**WELWYN HATFIELD BOROUGH COUNCIL  
EXECUTIVE DIRECTOR - PLANNING, PUBLIC PROTECTION AND GOVERNANCE**

**DELEGATED APPLICATION**

**Application No:** 6/2021/3423/VAR  
**Location:** Northaw House Coopers Lane Northaw Potters Bar EN6 4NG  
**Proposal:** Variation of condition 1 and 2 (amendment of wording of previously approved application) and condition 4 (change list of approved drawings) on planning permission 6/2019/0218/LB  
**Officer:** Mr William Myers

Title
 SETTLEMENT UNIT 1
 PLOT 21 ELEVATIONS

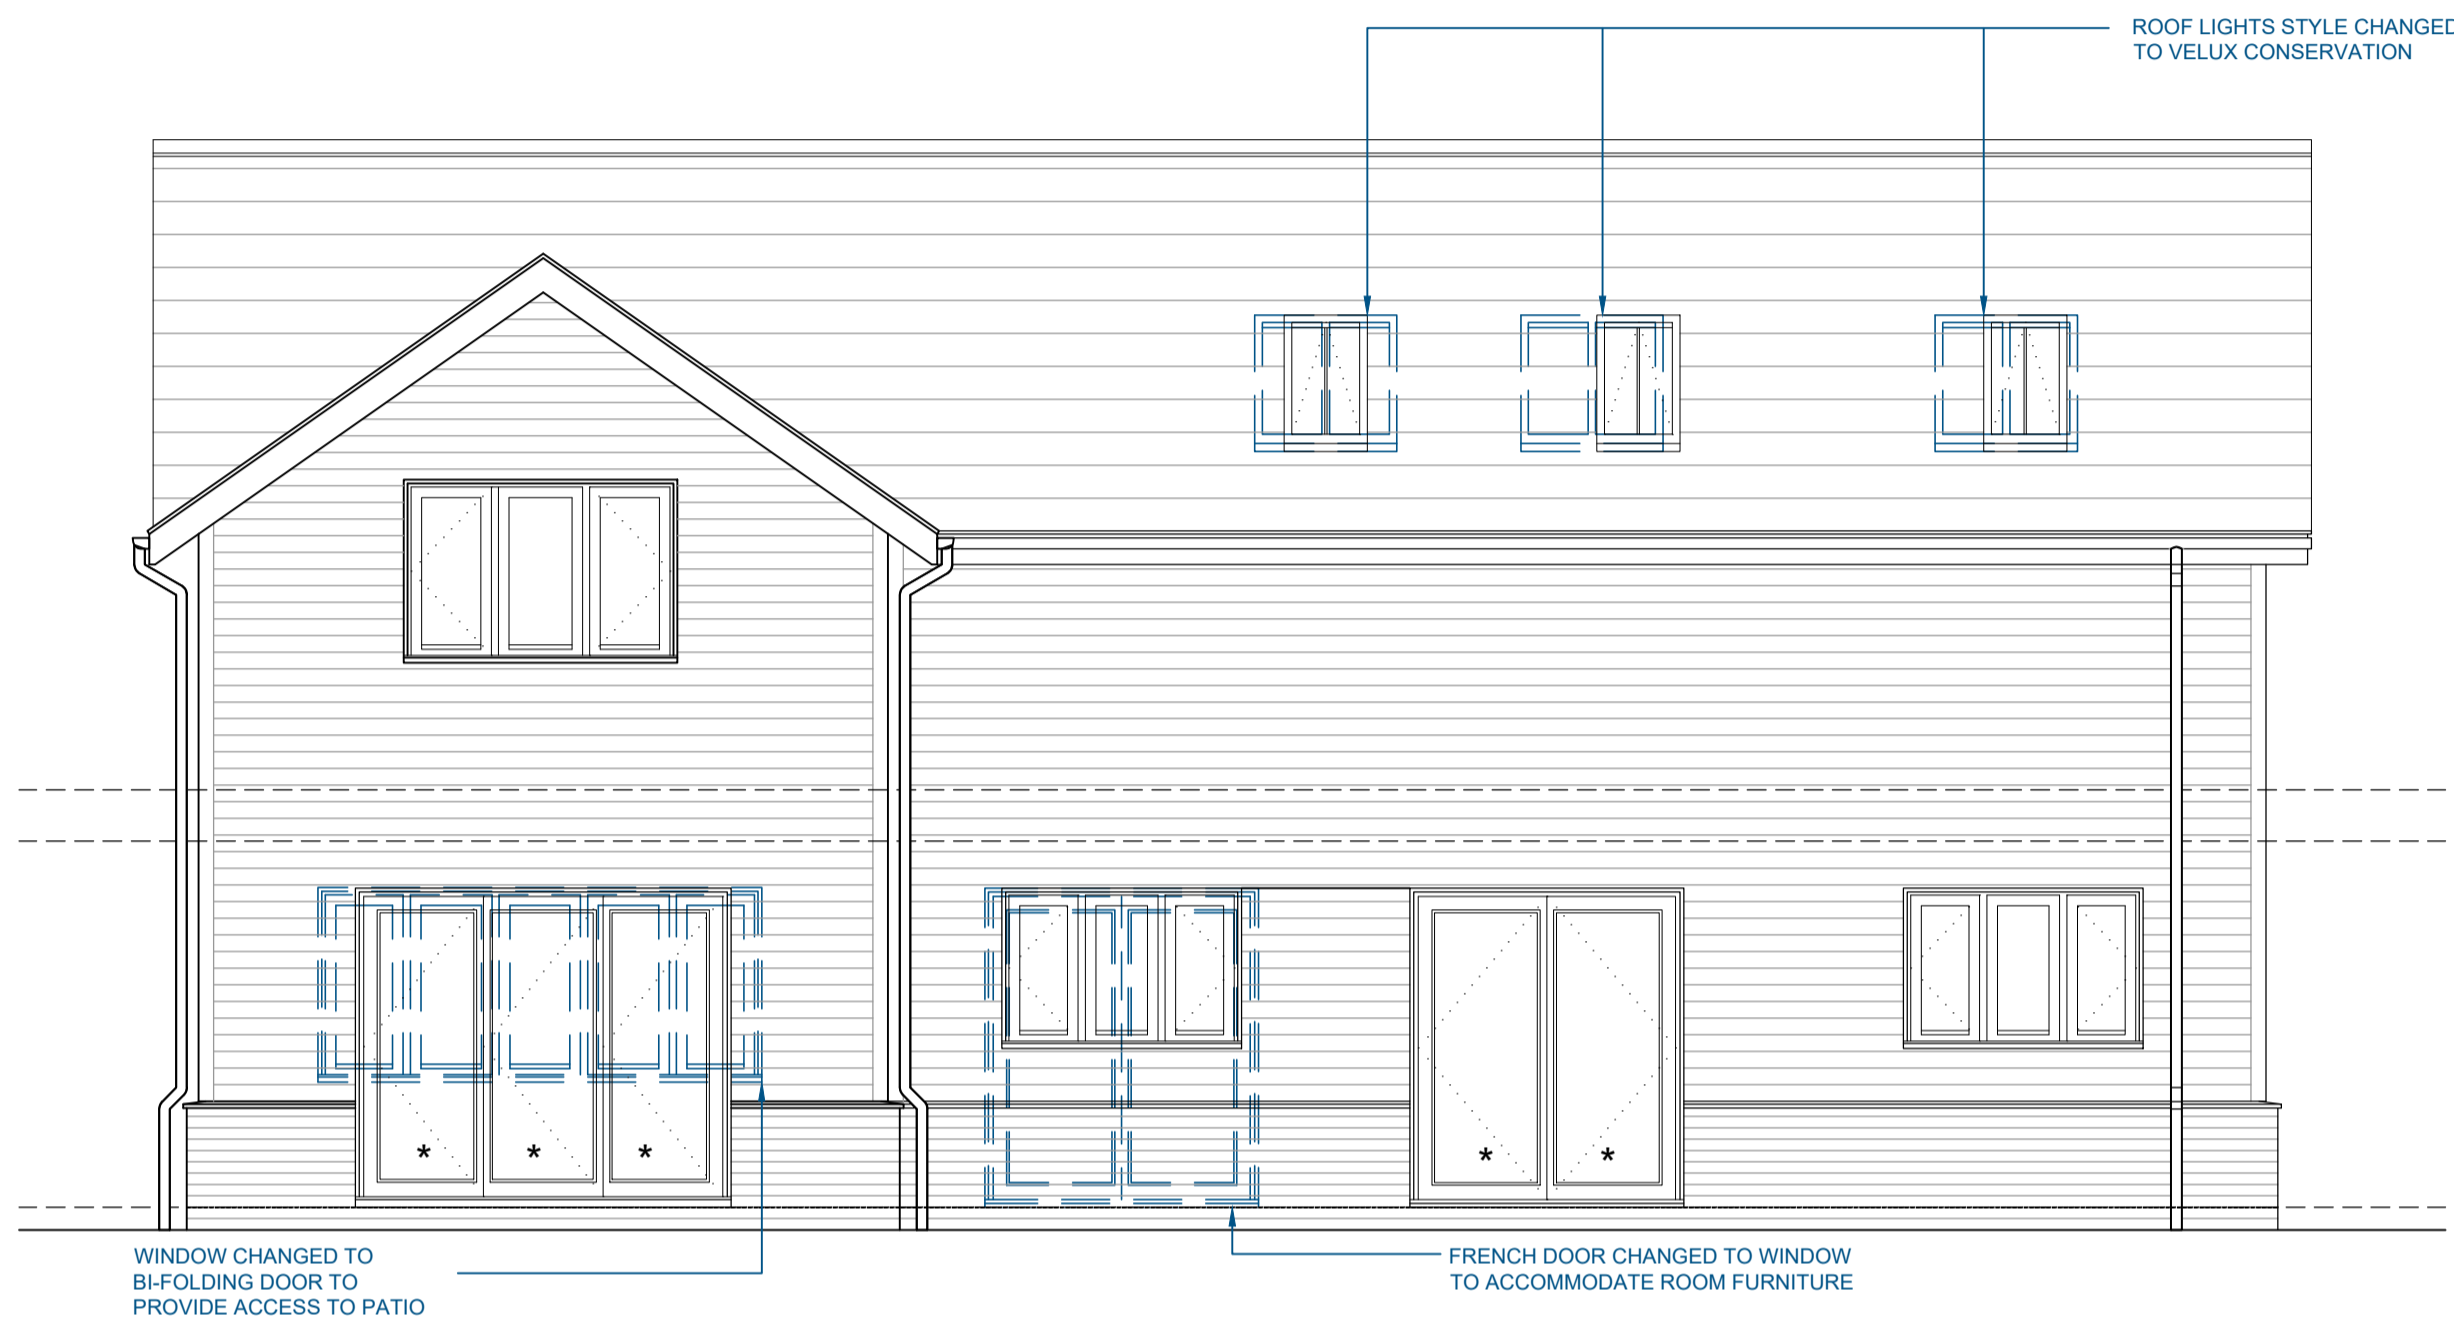
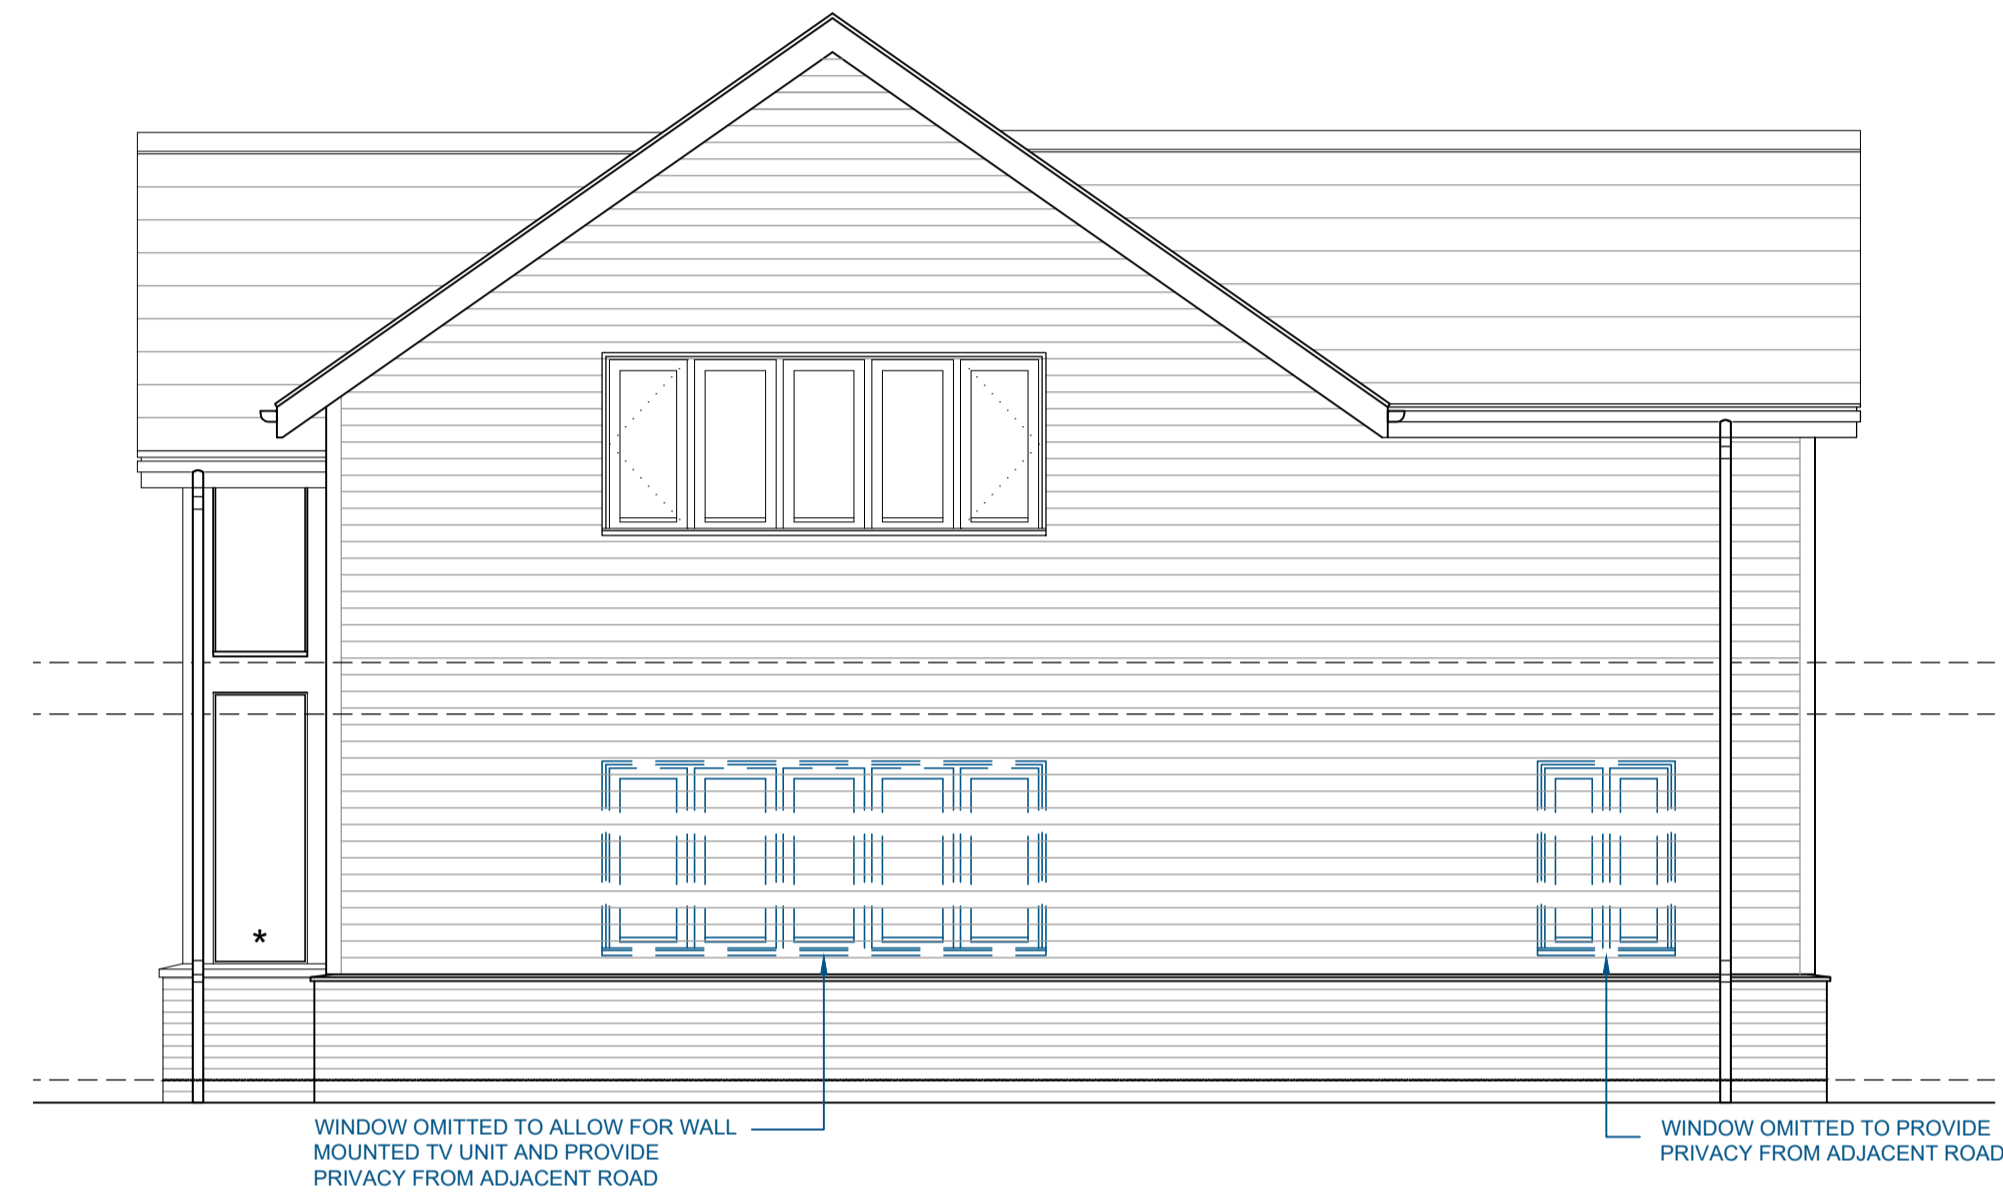
<ul style="list-style-type: none"> <li>• The replacement of the proposed two storey glazed feature on the front elevation of settlement unit 1 (plots 21-23), with a two storey porch feature with a gable roof. Including the removal of one rooflight within the front elevation, remaining rooflights to conservation velux windows.</li> <li>• The use of timber cladding on the side elevations of settlement unit 1 (plots 21-23) instead of brick, as well as the removal of the ground floor windows within these side elevations.</li> <li>• The reposition of windows and patio doors within the rear elevations of these buildings, within settlement unit 1 (plots 21-23)</li> <li>• The replacement of the proposed entrance feature on the front elevation of settlement unit 2 (plots 24 – 25), with a two storey porch feature with a gable roof, including the removing of a rooflight, as well as the removal of two roof lights and their replacement with four rooflights, within the front elevation. All roof lights would be conservation velux windows.</li> <li>• The changing of the proposed fenestration detailing within the side elevation which is opposite to the garage, with its removal at ground floor level and its alteration at first floor level, within settlement unit 2</li> <li>• The changing of the proposed fenestration detailing within the rear elevation, which would include the insertion of a window to the rear of the linked garage, the replacement of patio doors with a window and the alteration of the proposed glazing within the gable projection.</li> <li>• The separation of plots 24 and 25</li> <li>• The removal of two ground floor windows within the Farmhouse (plot 26)</li> <li>• Minor changes to the internal access road and parking layout</li> <li>• The changing of the trigger point within conditions 1 and 2</li> </ul> <p>It is important to note that permission 6/2021/2191/VAR gave consent for materially similar alterations to the built form within the site but that this permission did not include the variation of conditions 1 and 2.</p>
